Our Ref: 66504/LT/002

29th October 2019

**Former Shredded Wheat Site, Broadwater Road,
Welwyn Garden City, AL8 6UN**

Please see below Curtins responses to comments on the Surface Water Discharge made by Thames Water development Team in their email dated 12th August 2019.

Project:	SHREDDED WHEAT, METROPOLITAN			Status:	STAGE 4	
Drg Title:	ATTENUATION TANK DETAIL			Drawn By:	NMH	Checked By: MS
				Designed By:	NMH	Date: 12.12.19
				Scale:	NTS	
Project No:	Originator:	Zone:	Level:	Type:	Discipline:	Category / Number:
066571	- CUR	- 00	- 00	- DR	- C	- 98006 -P01

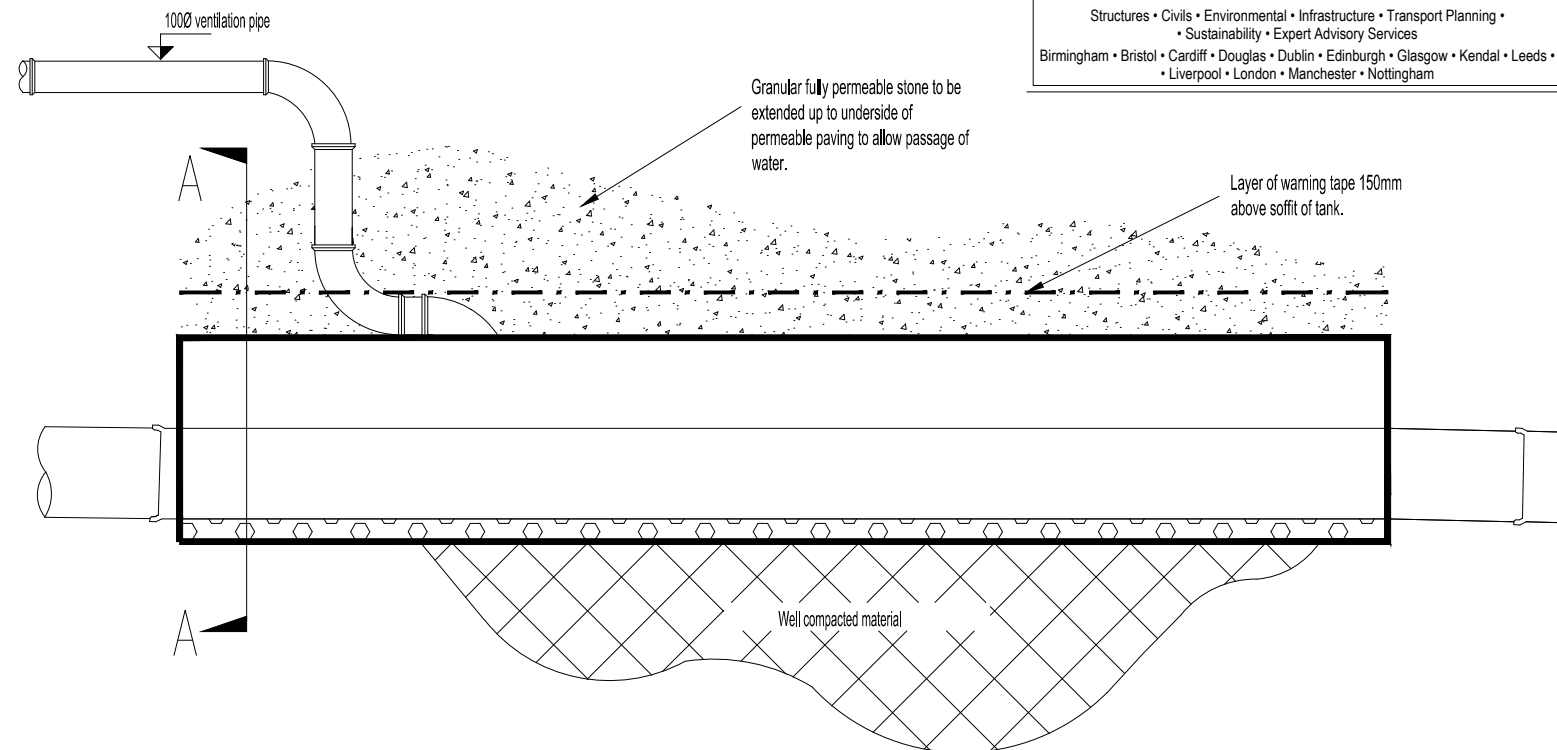
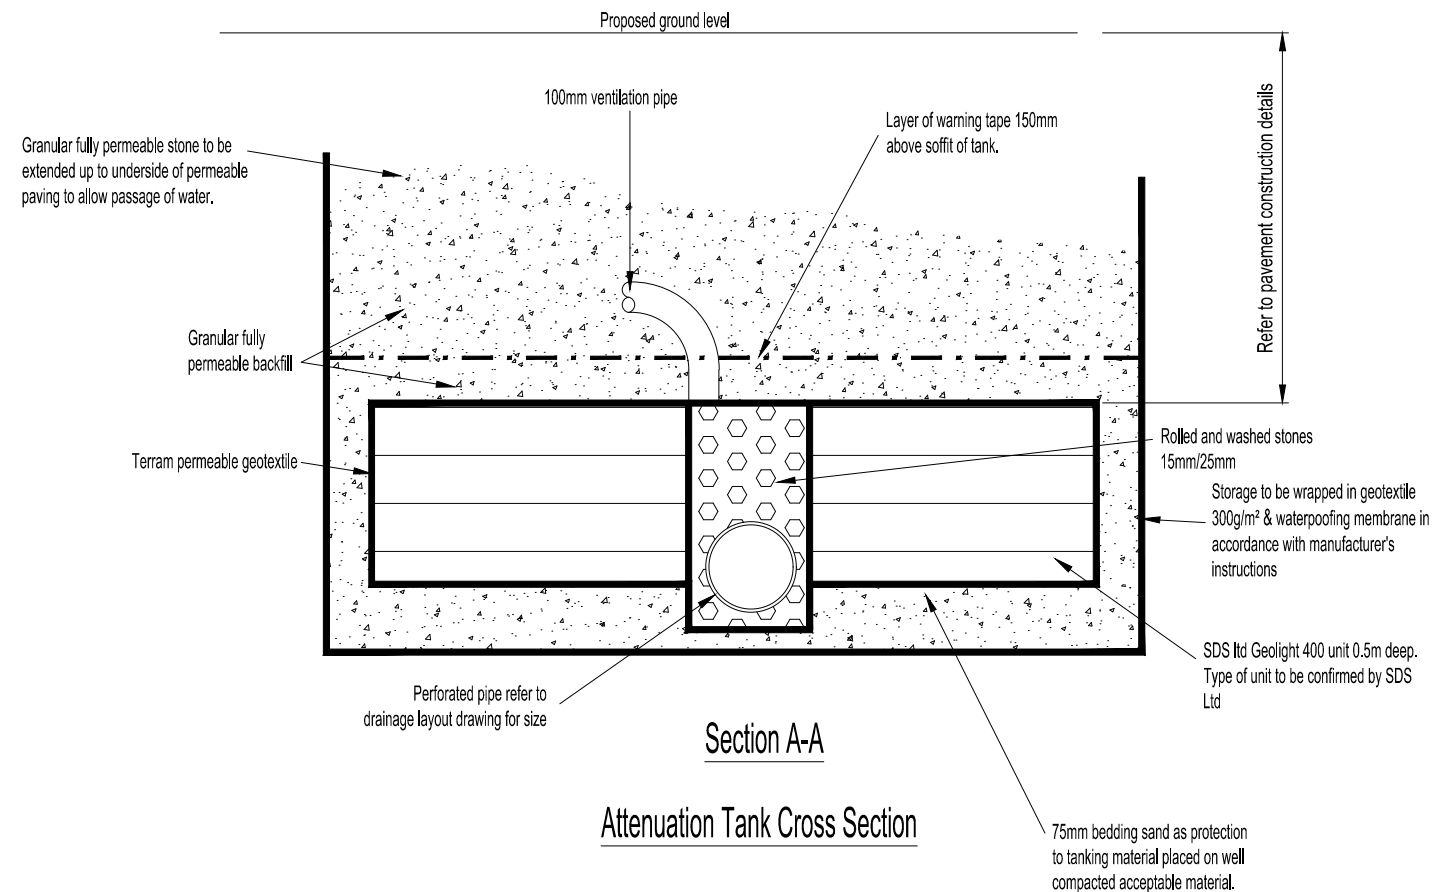
The strategy lack detail only calculations which don't articulate the intended flows etc. Give a brief description of volumes, Discharge rates say 1:1, 1:10, 1:30 and 1:100. Also show and give capacity of any attenuation

Attenuation is by storage tank at 392m²

Attenuation is by storage tank at 334m²
